**Smalls Road Public School, 3B Smalls Road, Ryde (SSD 8372)**

## **TAB A – Detailed comments on Smalls Road Public School SSD8372**

Sheet Subject
**DROP-OFF AND PICK-UP BAY
 PROPOSED RESTRICTIONS
 SIGNAGE PLAN**

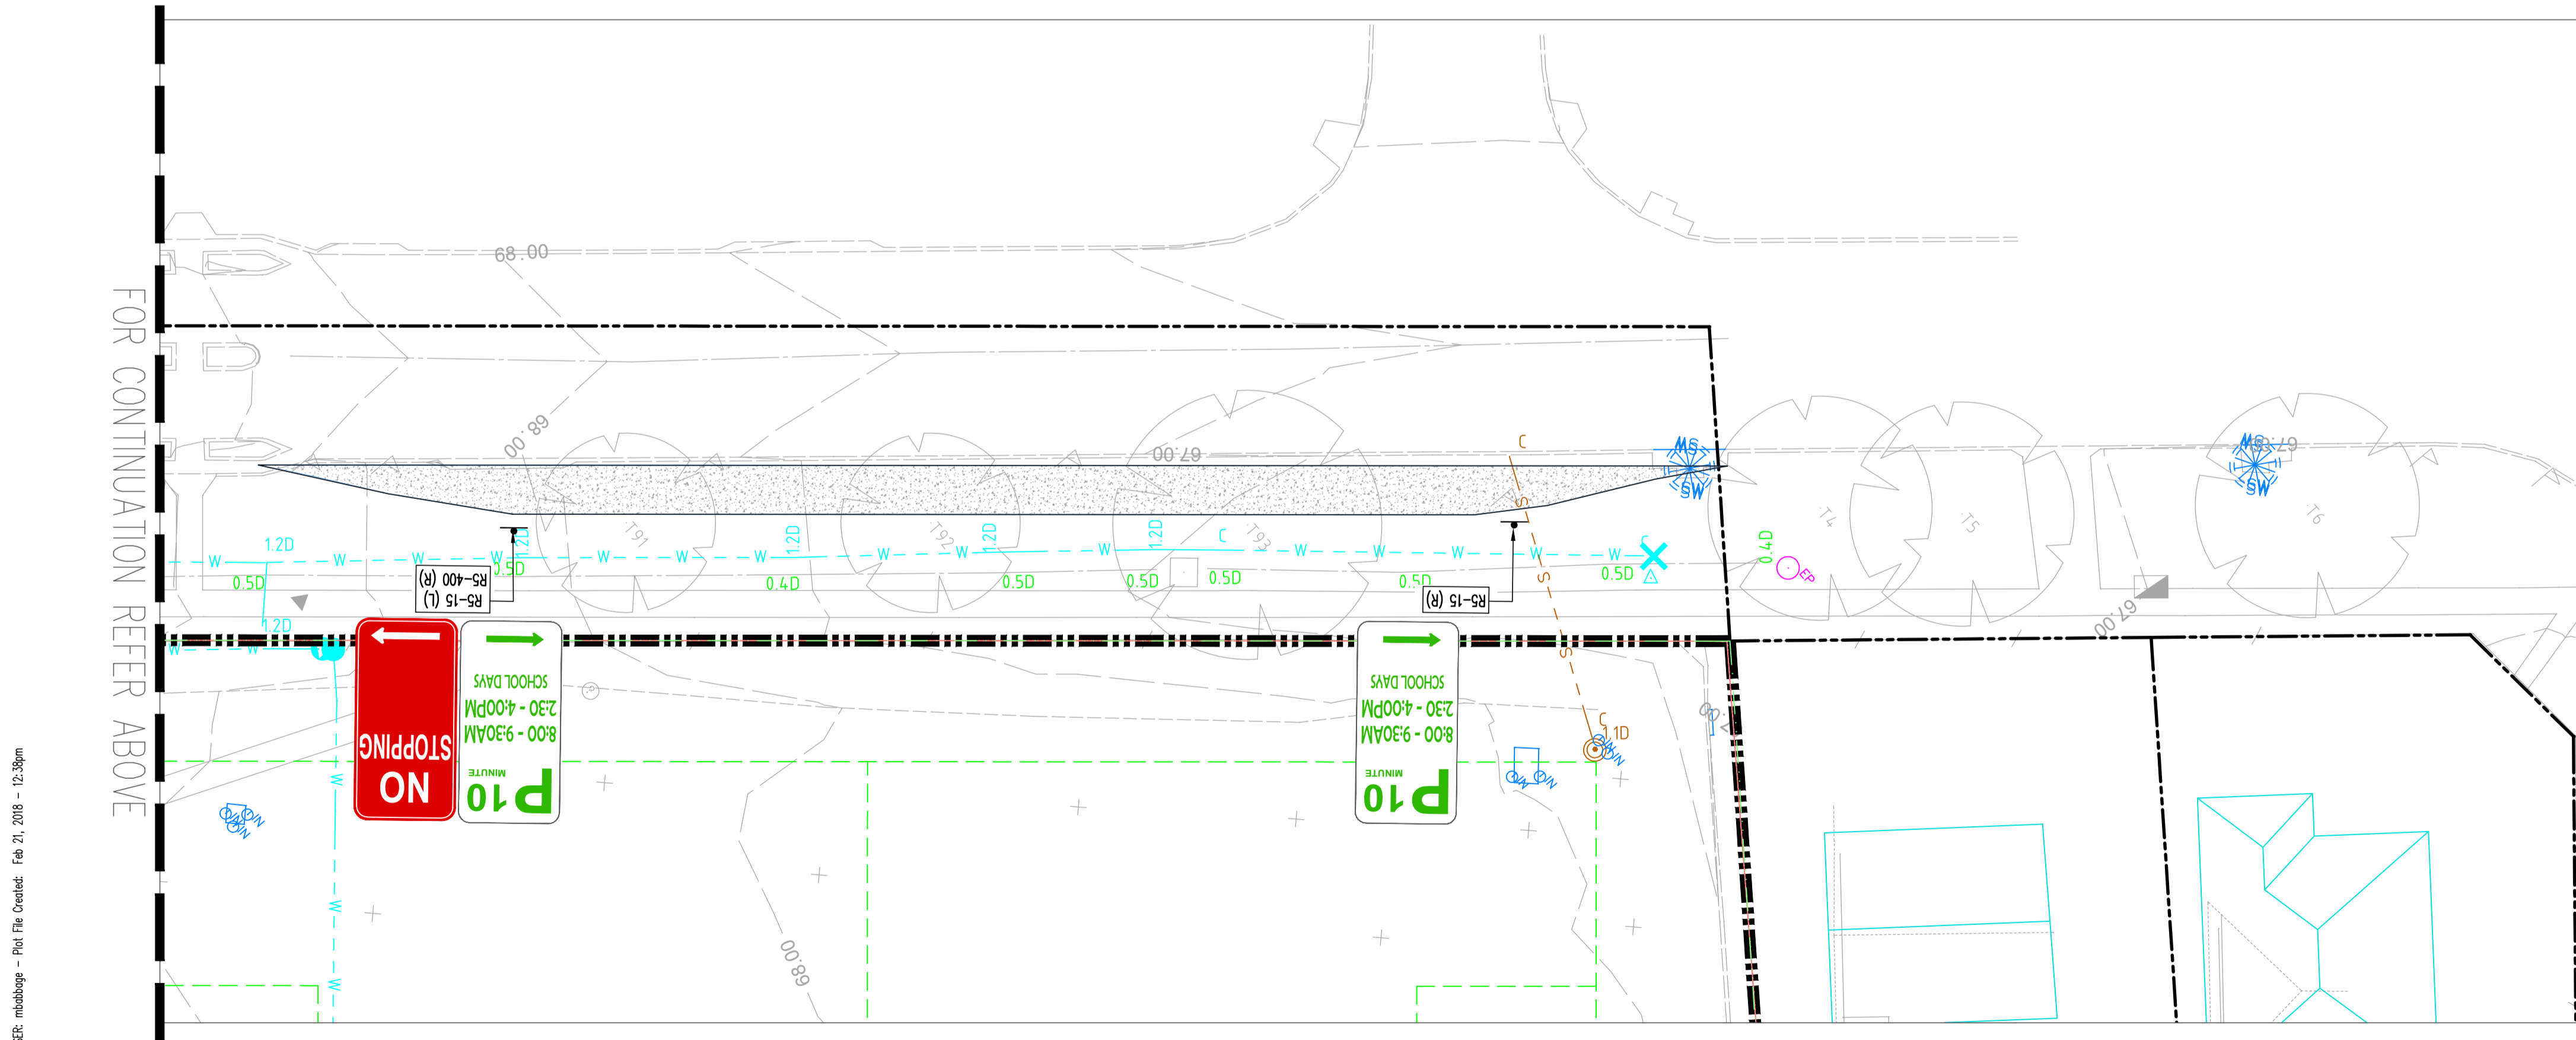
The proposed site plan (Appendix C Architectural Plans) indicates 5-minute parking zone while the Transport and Accessibility Impact Assessment report assessed the proposed drop-off and pick-up facilities based on 10-minute parking zone.

The above content should be clarified and the assessment should be revised as necessary. The EIS should provide a concept plan for the signage and line-marking required to accommodate pick-up/drop-off, bus layover and any other traffic or parking control devices.
